**RE: EPC SF2219 – Mayberry Filing 3 GEC Comment Response**

The intent of this letter is to give a broad overview of changes between the last Filing 3 Grading and Erosion Control Plans submission and the 3<sup>rd</sup> submission. Responses to individual comments can be found on the marked up PDF following this letter. A broad overview of the changes are as follows:

# GRADING & EROSION CONTROL PLANS MAYBERRY, COLORADO - FILING NO. 3

C8.2

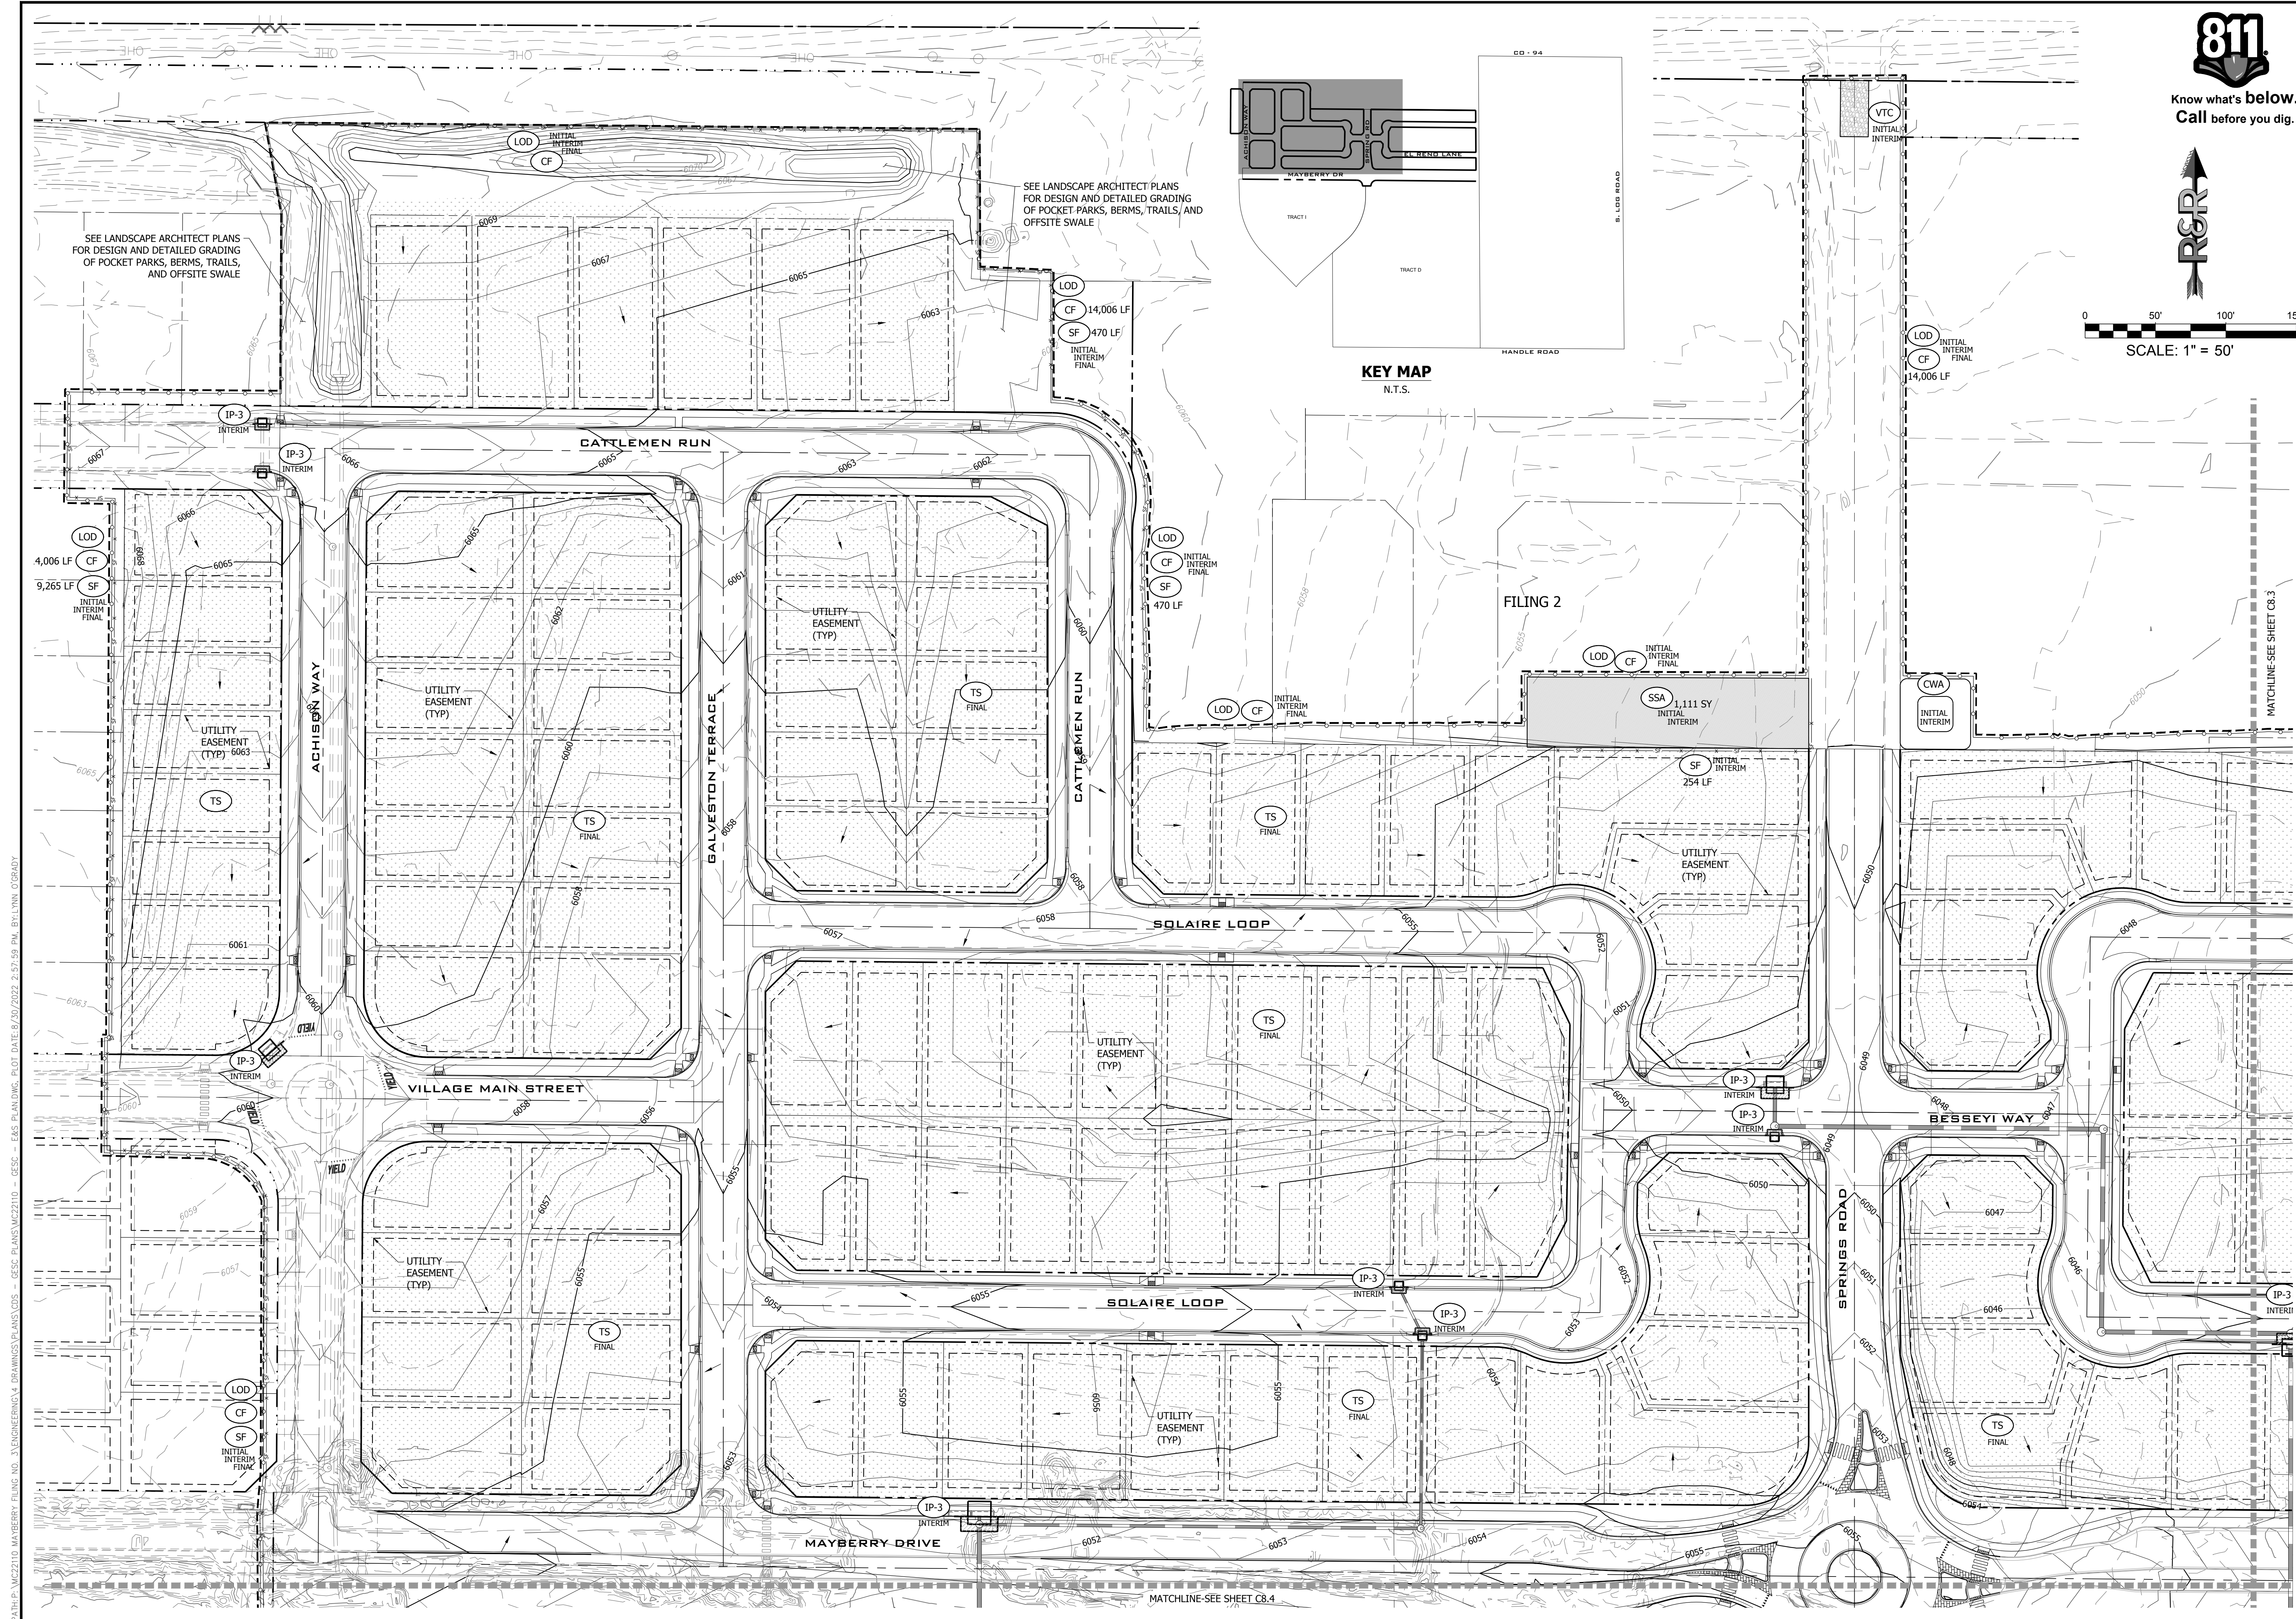
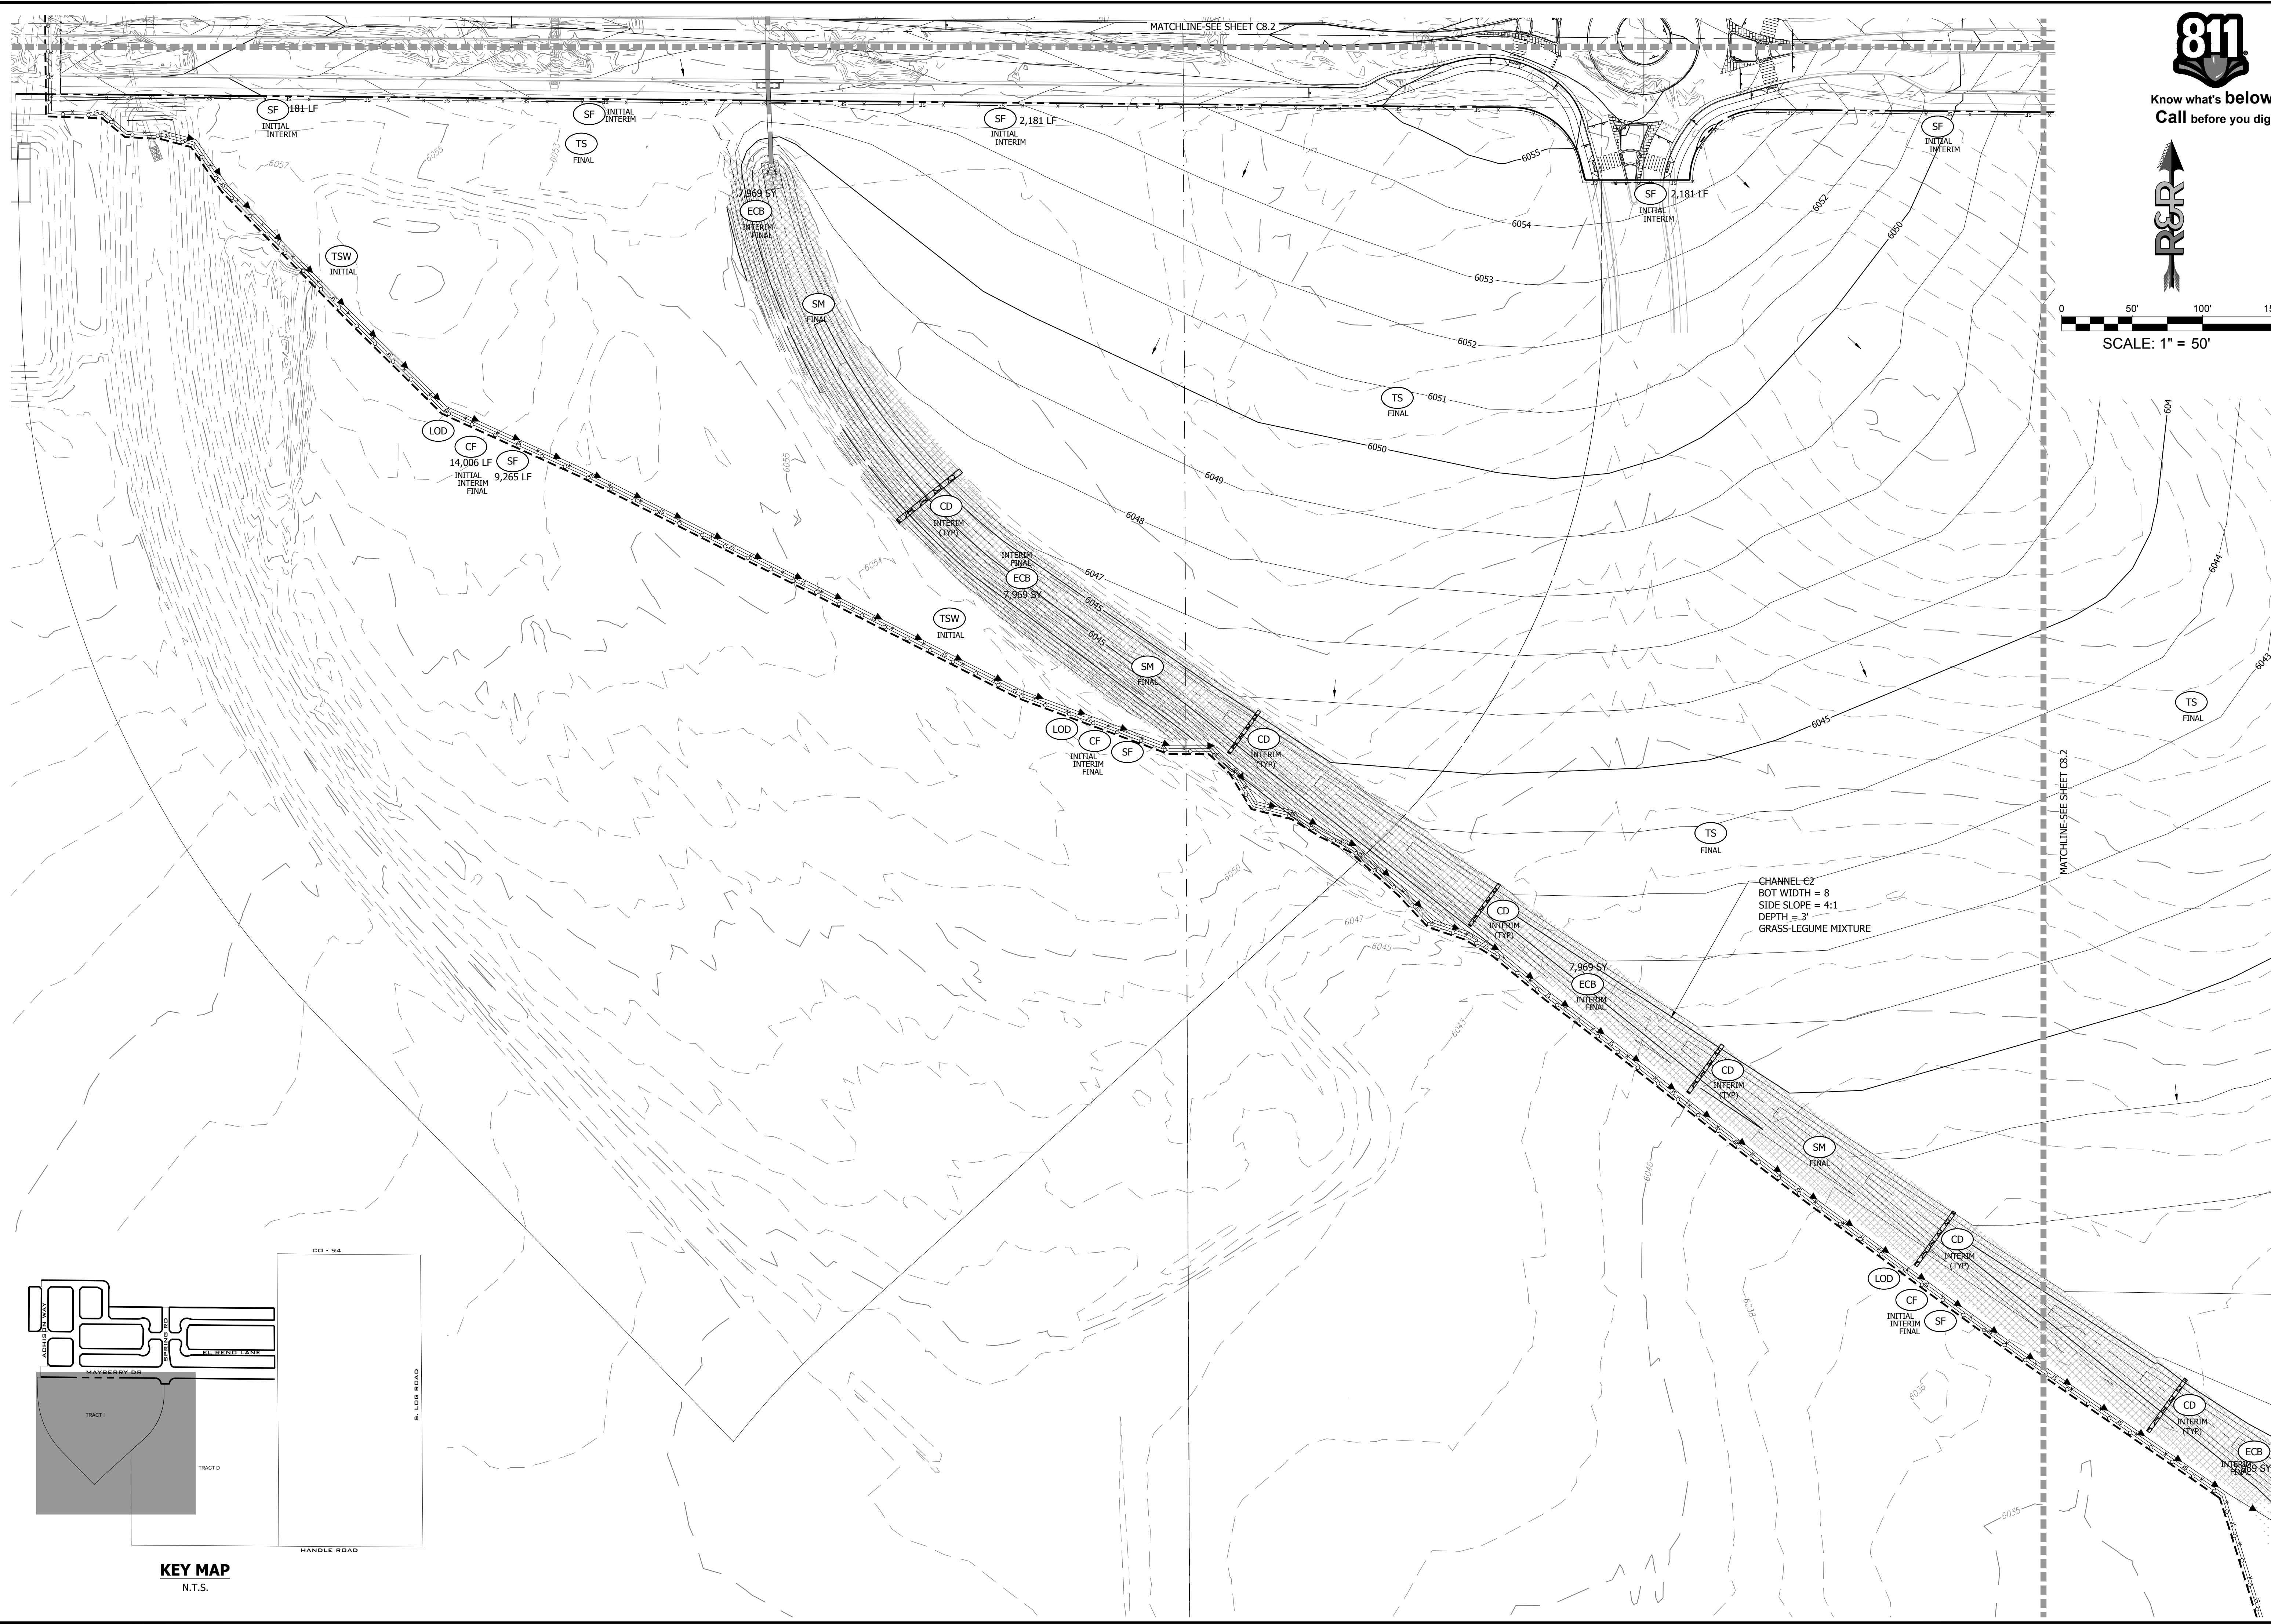
Please provide for review and approval of berms, trails, and swales.

show locations of curb socks (interim) Curb sock locations are now shown and labeled.

add to legend. show both existing and proposed SW flow arrows. Prop. SW flow arrows have been added to the legend. Existing SW flow arrows (shaded) have been added to the plans and legend.

Please show Limits of Construction. If "limits of disturbance" and "limits of construction" are the same, change LOD line type to "limits of construction/disturbance" or otherwise show as separate line types for each on the legend and figure.

SF and CF should be labeled as Initial/Interim, not final (typ.) "Final" callout removed.

Please show all drainage easements.

was this grading completed under filing 1? If so, please adjust the LOD and show contours as existing.

label parcel. Is this also Filing 2?

TS is temporary seeding. This is in the legend on Sheet C8.2 Add to legend.

Limits of construction and limits of disturbance are the same. The legend now clarifies this.

All drainage easements are now shown and labeled.

The grading in this location was completed in Filing 1. Contour linetype has been revised accordingly. "Final" callout removed.

"Final" callout removed.

Parcel labeled as Filing 4
